Harnett County

Permit Number: BCOM2301-0004

Description: **28 x 52 commercial modular for temp use/site bltdeck**

Cortland

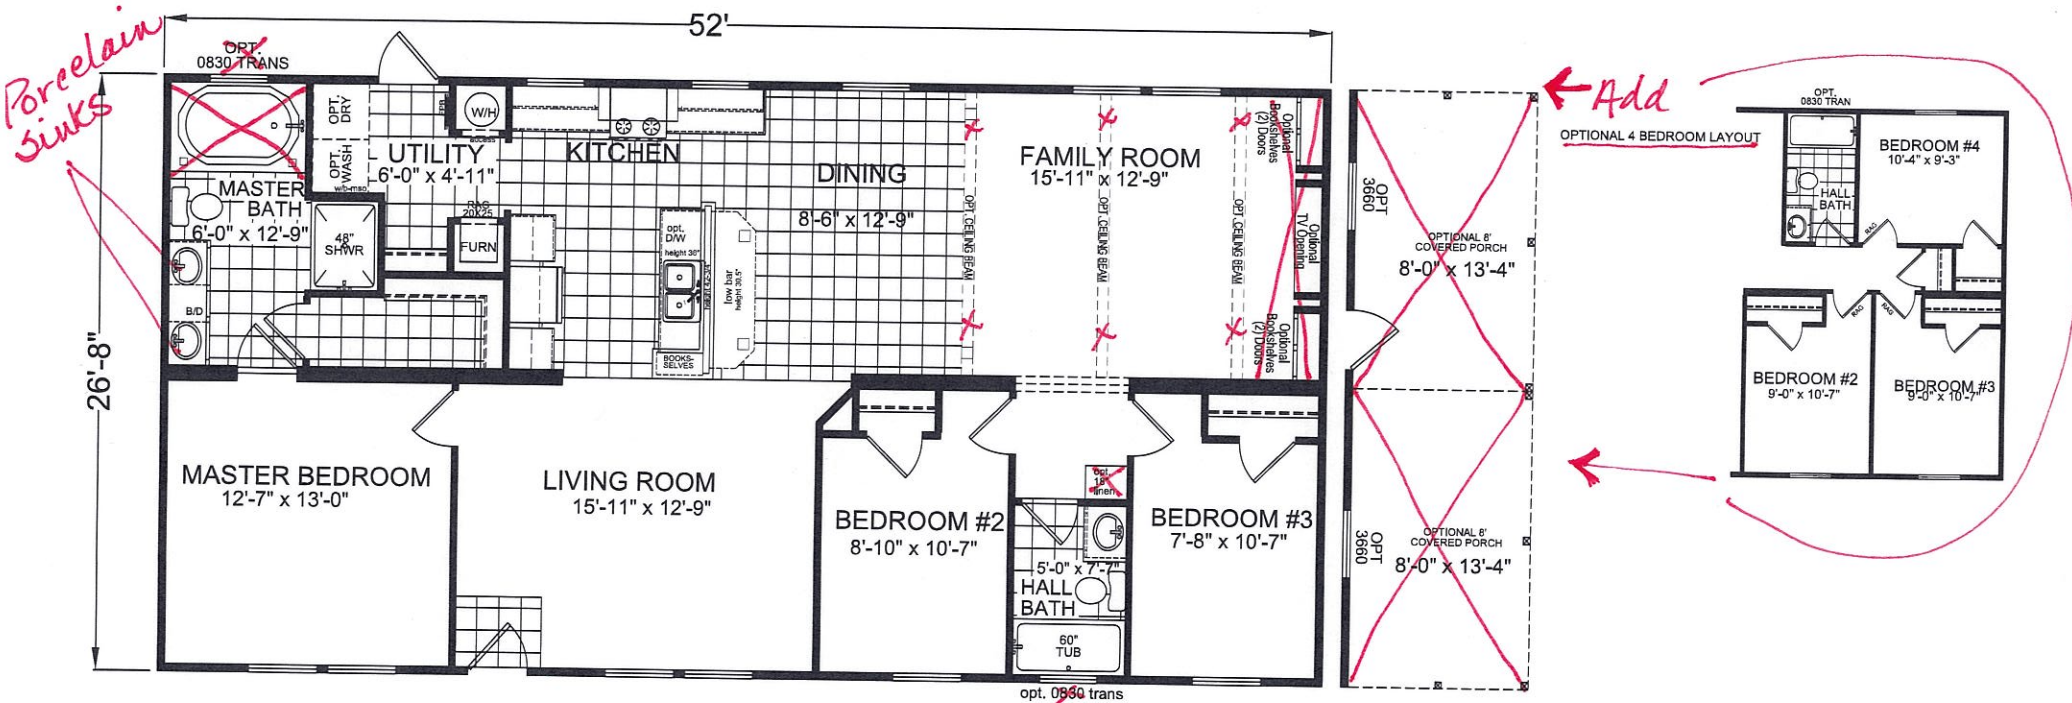
SENT DATE	RETURNED DATE	DUE DATE	TYPE	CONTACT	STATUS	REMARKS
Review Group: ALL						
4/18/2023	4/24/2023	5/2/2023	Commercial Building Review	Brad Sutton	DISAPPROVED	
Notes:						
Plan info is for a manufactured home. Office trailer must be listed as a commercial NC Modular. Need correct floor plan and life safety layout						
4/18/2023	4/26/2023	5/2/2023	FIRE MARSHAL	Leslie Jackson	DISAPPROVED	See Notes
Notes:						
The wrong scale. LJ						
Review Group: AUTO						
1/11/2023	4/18/2023		COMMERCIAL INTAKE	CP Bucket	DISAPPROVED	
Notes:						
4/24/2023			Commercial Building Review	Building Bucket		
Notes:
